From: Mundy, Ben - Oxfordshire County Council <Ben.Mundy@Oxfordshire.gov.uk>
Sent: 01 November 2022 16:35
To: Neil Cottrell <N.Cottrell@dorchestergrp.com>
Cc: White, Joy - Oxfordshire County Council <Joy.White@Oxfordshire.gov.uk>; Andy Bateson <Andy.Bateson@cherwell-dc.gov.uk>; David Lowin <David.Lowin@Cherwell-DC.gov.uk>; Nichols, Chris - Oxfordshire County Council <Chris.Nichols@Oxfordshire.gov.uk>
Subject: RE: Oxfordshire County Council response to 22/02848/DISC, Heyford Park, Camp Road, Upper Heyford, OX25 5HD Condition 6 of Planning Permission 18/00825/HYBRID

CREATING PEDESTRIAN AND CYCLE PERMEABILITY

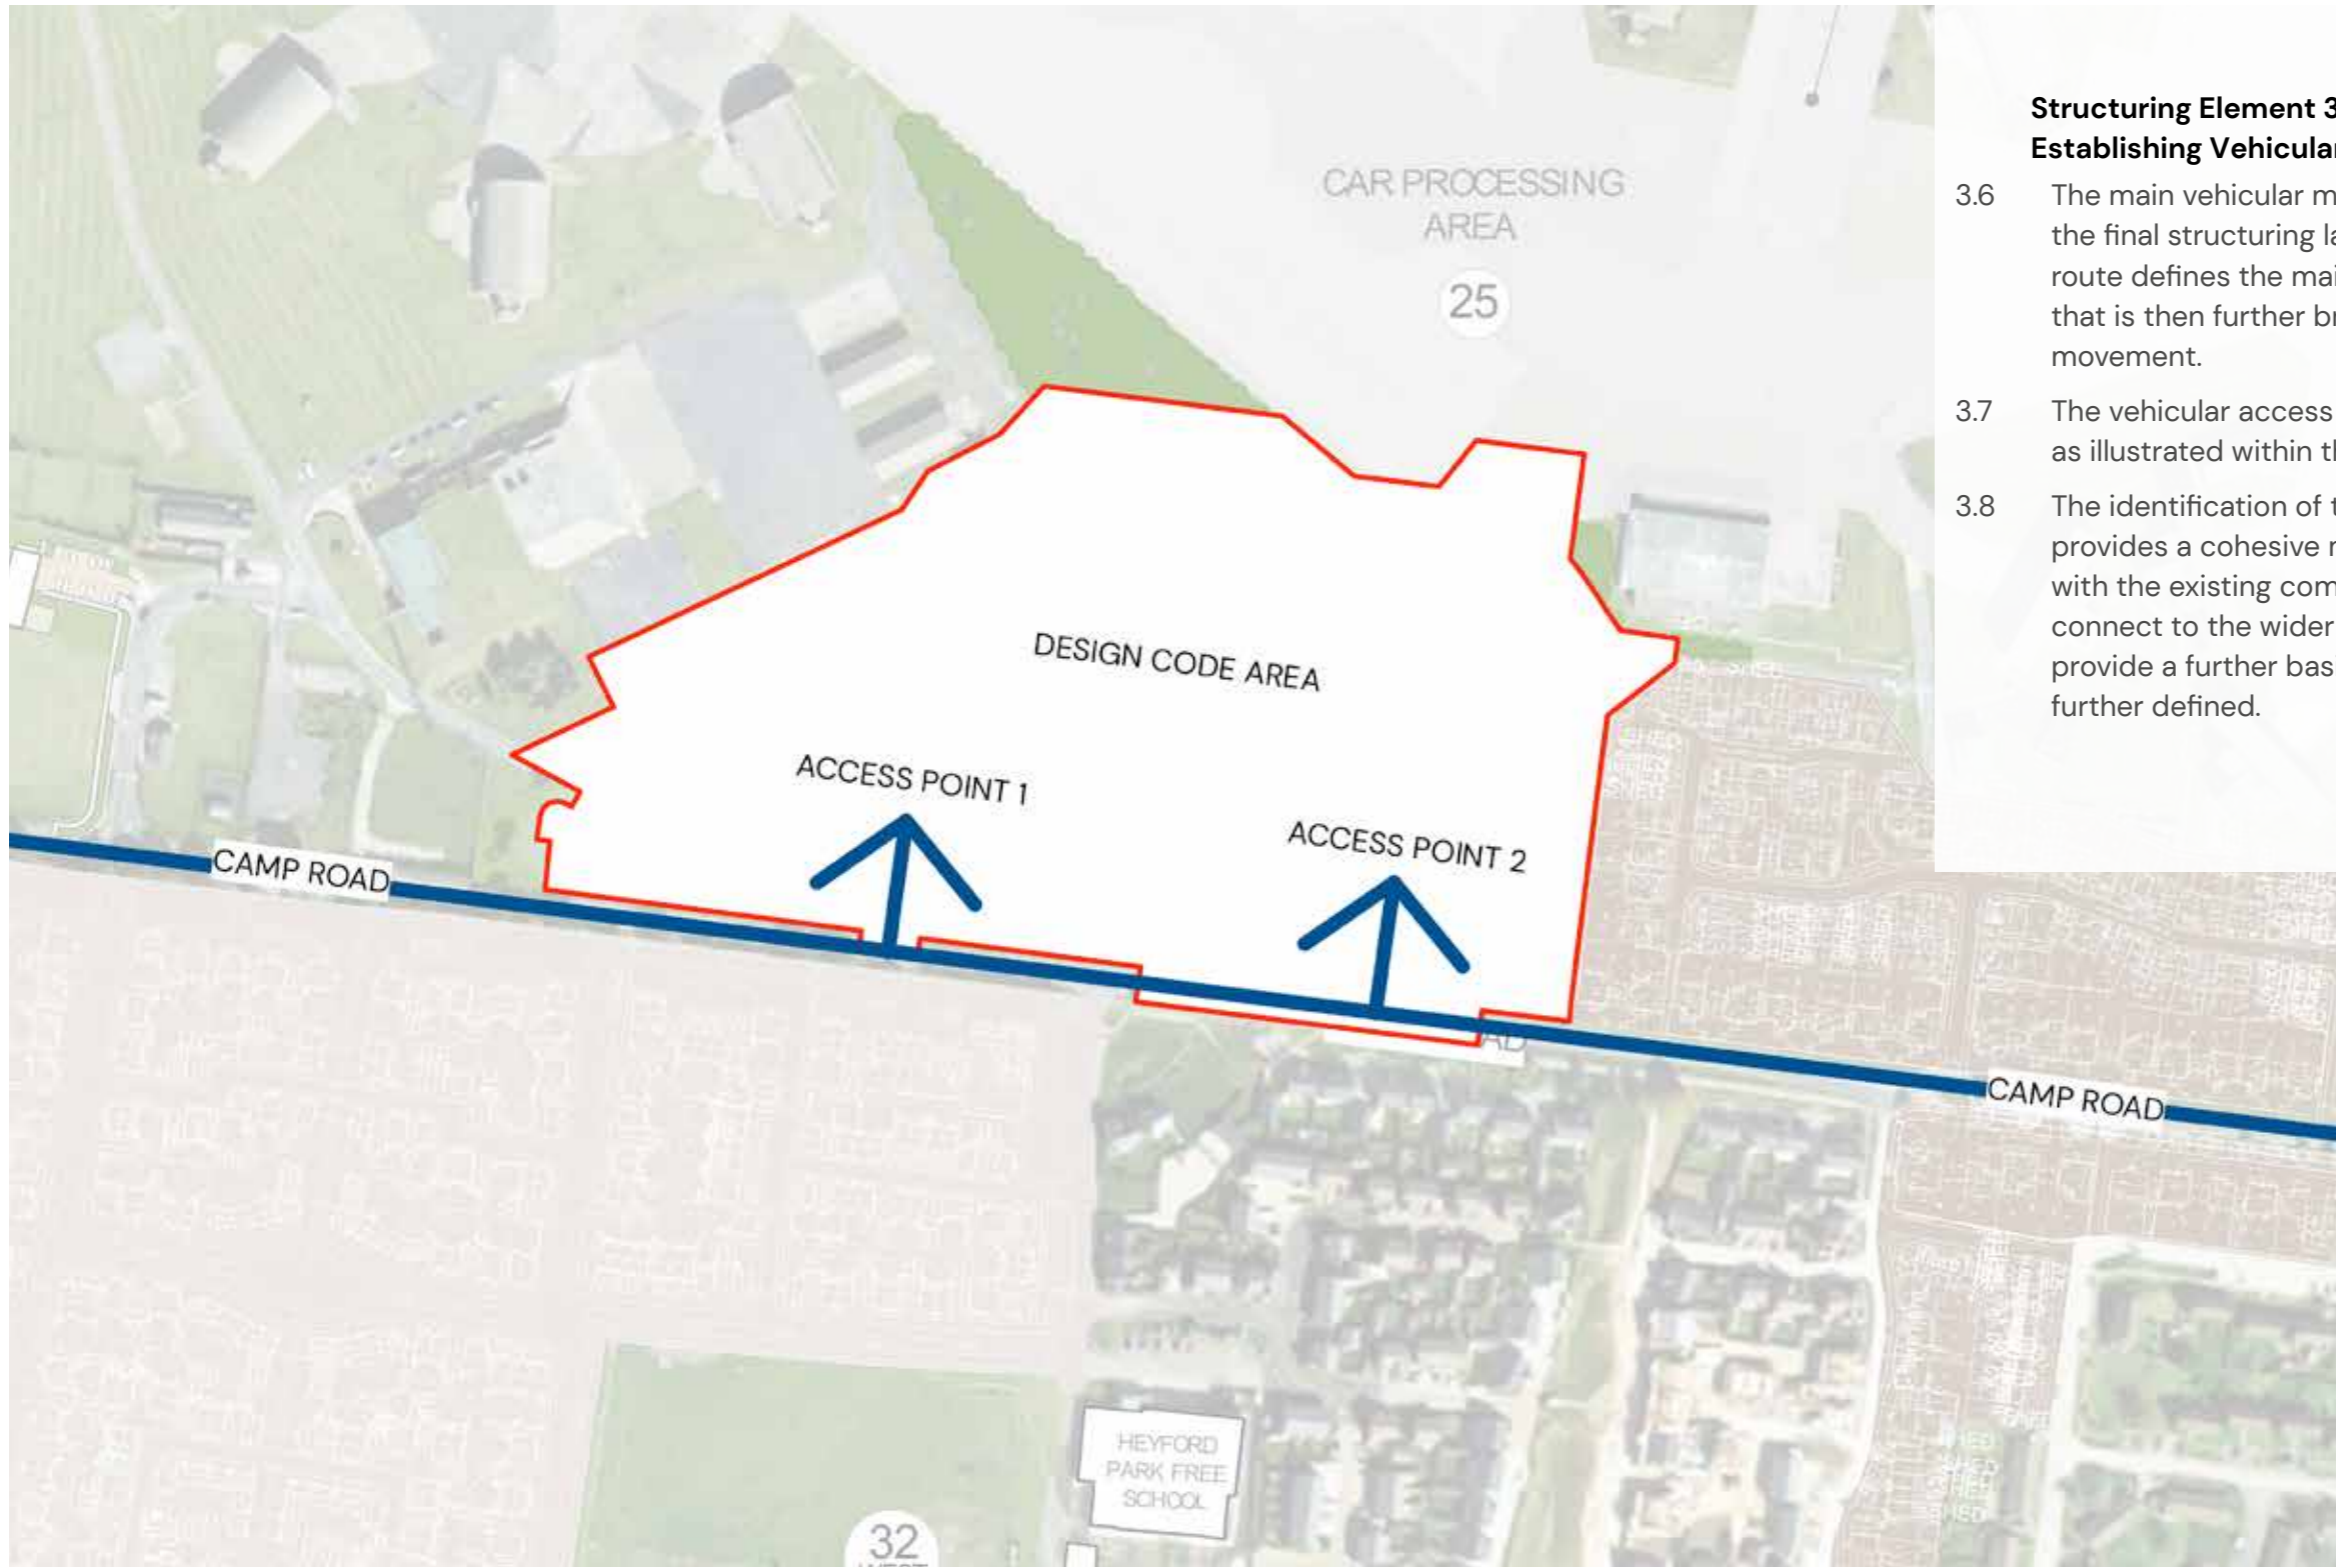
2. **Conformance to LTN 1/20:** Inside Phase 10 the roads will have low traffic and be designed to 20mph, so cycling on the carriageway is acceptable, i.e. LTN 1/20 does not make that much difference. However, the rest of the site must be designed to LTN 1/20, which includes the new spine road and any off carriageway cycle/pedestrian links. This principle has been accepted by Dorchester, as they agreed the specification for the spine road which clearly references that it must be compliant with LTN 1/20 or any subsequent guidance. This specification is attached to the S106 agreement.

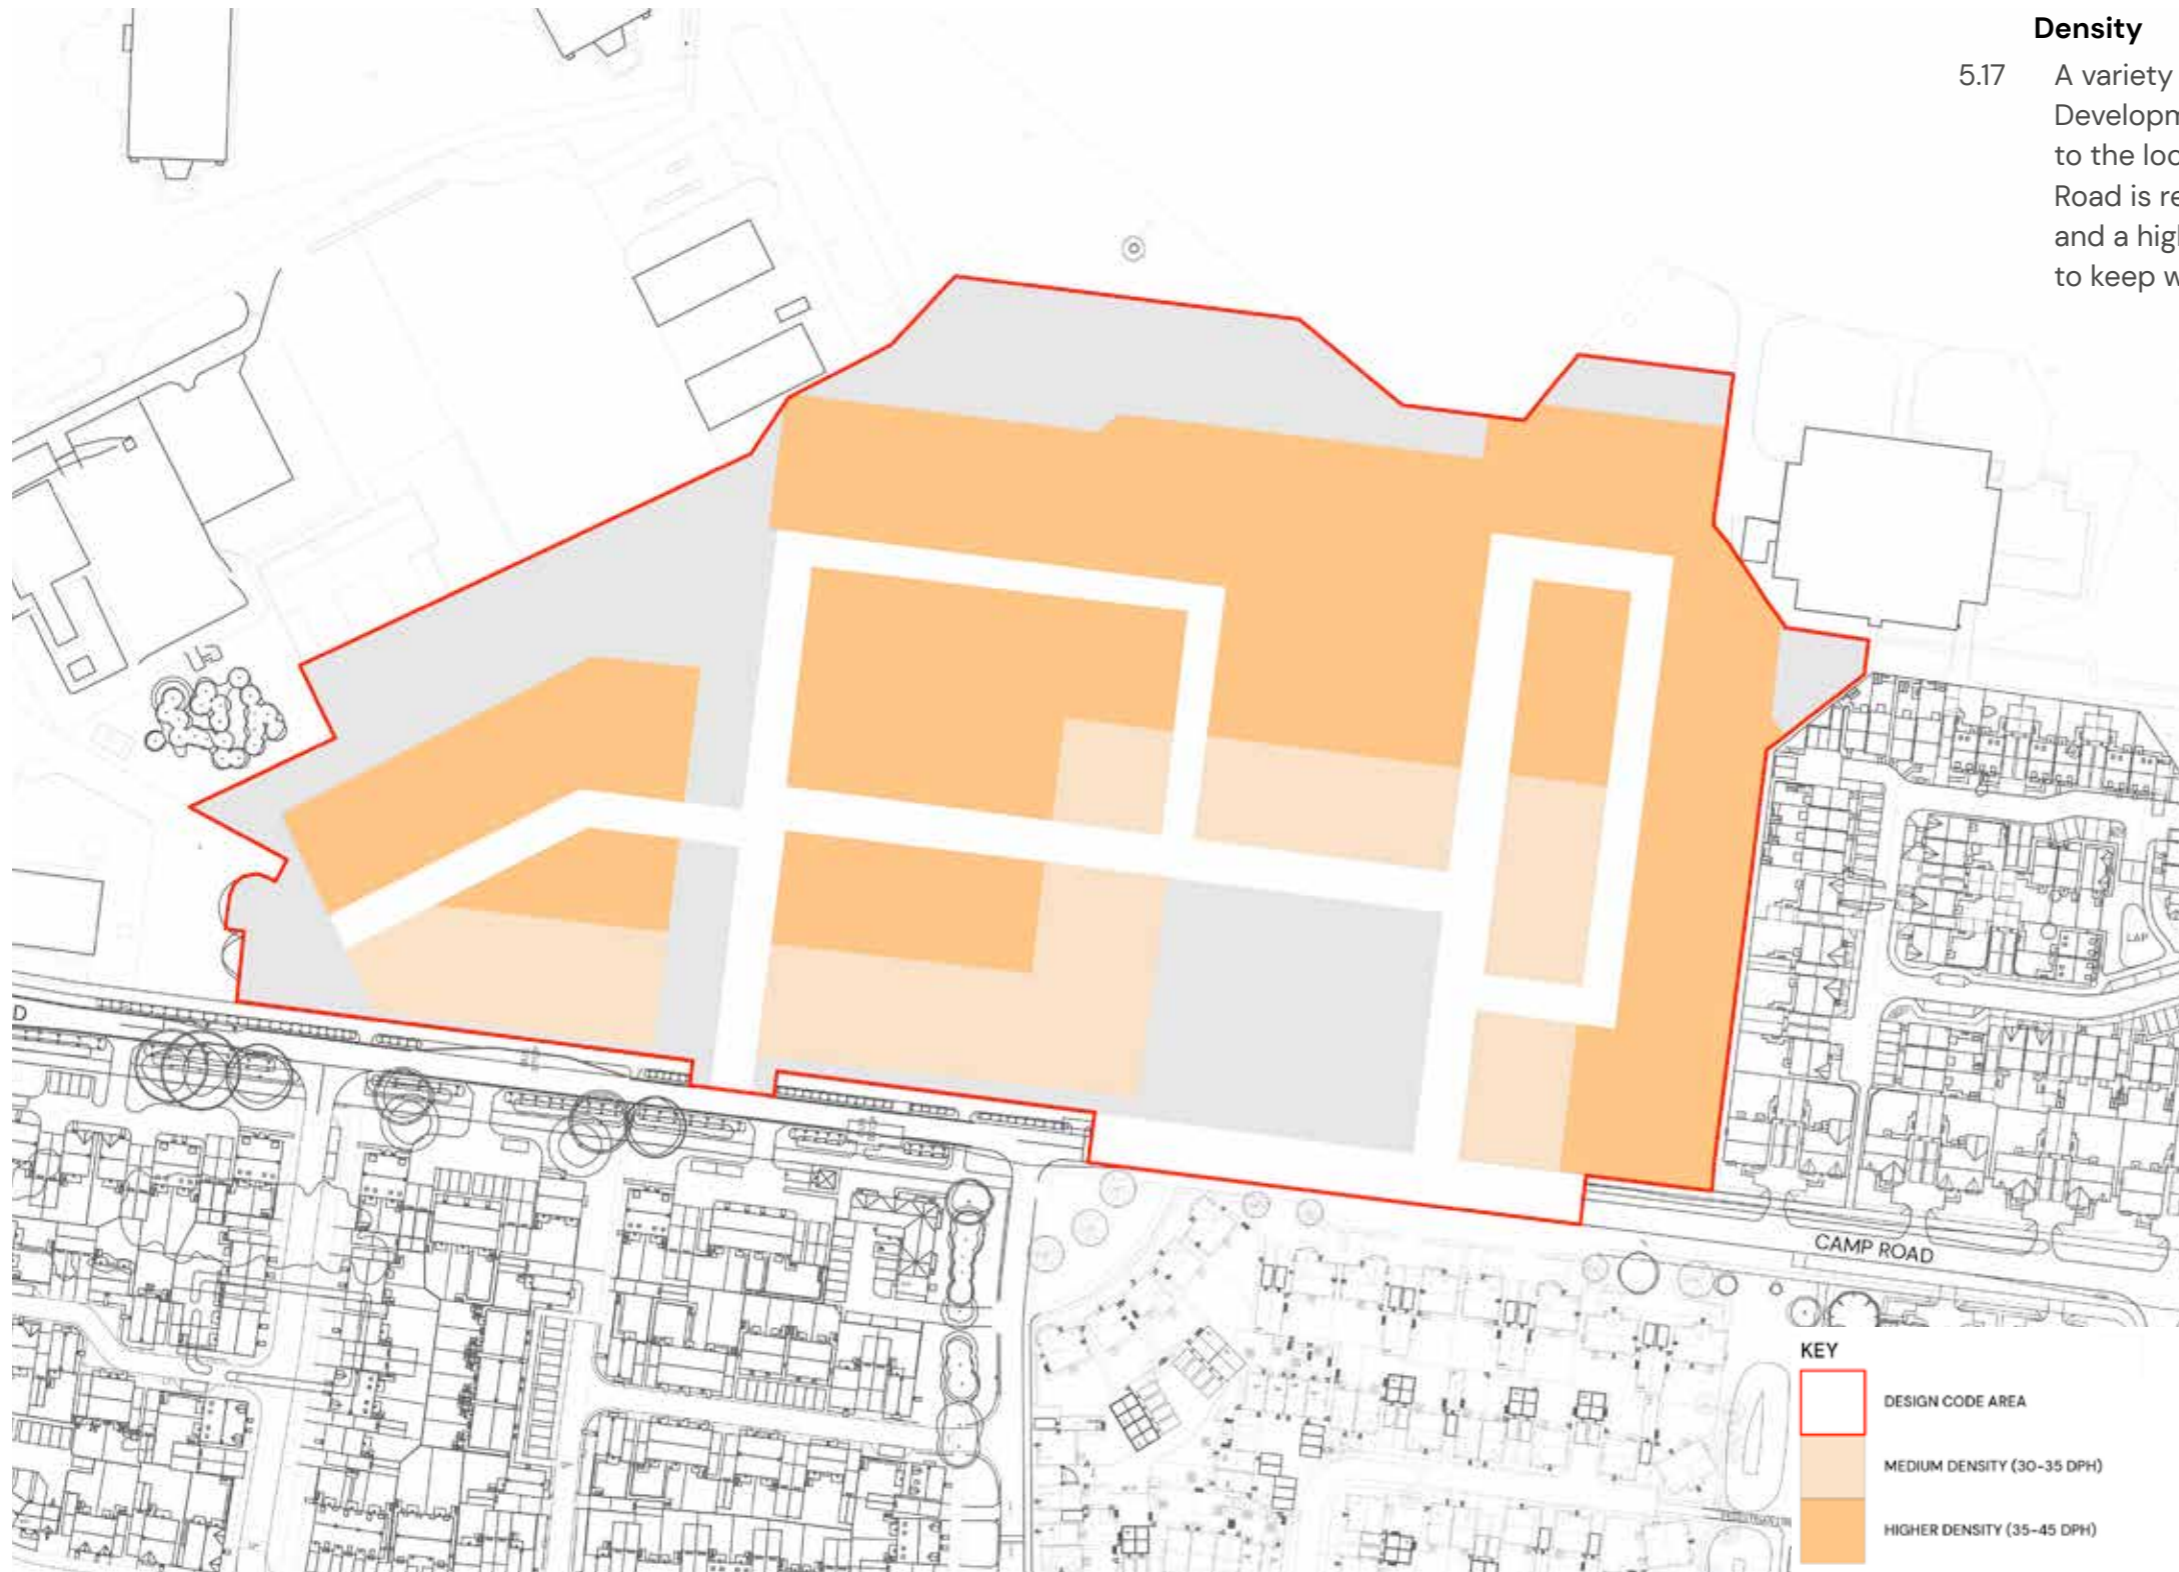
1. **Density:** we are of course not objecting to the number of dwellings on each phase. What we are saying is that the higher density housing should be concentrated around the bus route. This helps with patronage, which gives the bus service more of a chance of becoming commercially sustaining. It also ensures that the highest number of people are living within easy walking distance of the bus stops. I'd like this to be taken into account in future phases of 18/00825/HYBRID's masterplan.
